**Consultation Response from KC,  
Trees**

**2023/90956 rear of, 1, Sparks Road, Oakes, Huddersfield, HD3 4BX**

**Erection of 4 dwellings**

**Date Responded: 08/05/2024**

3. Proposed Site Layout
Scale 1:500

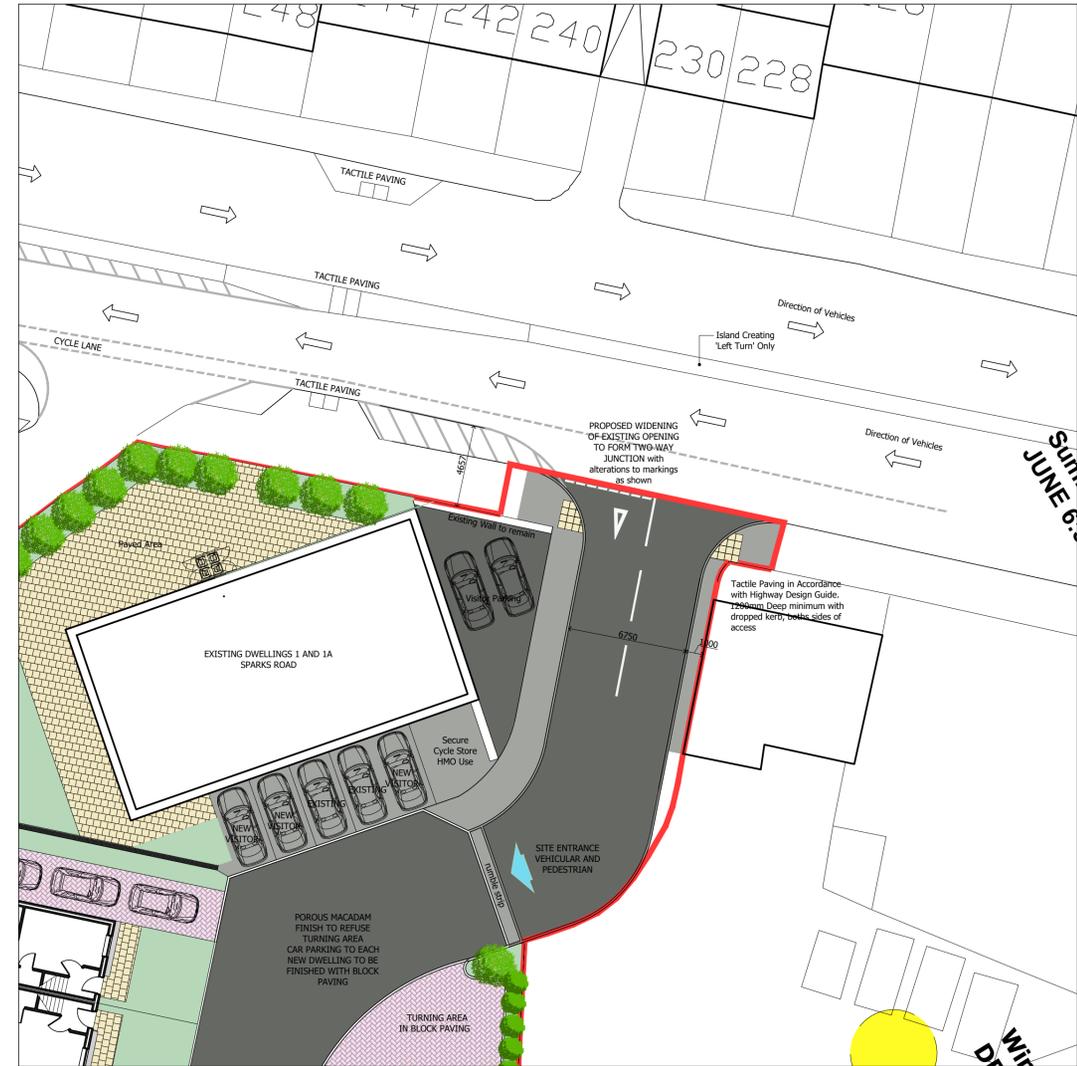
In the most recent site plan (22216 PLN-F 01 Existing and Proposed Site Plans) there are 2 rather than 3 dwellings being proposed to the west side of the site. This looks to take the new proposal outside of the RPA of T2 which is much more preferable. If this is the case there is a holding objection until the tree information is updated in order to show the Impact of the new proposals on the adjacent trees, which looks to be less than previously submitted.
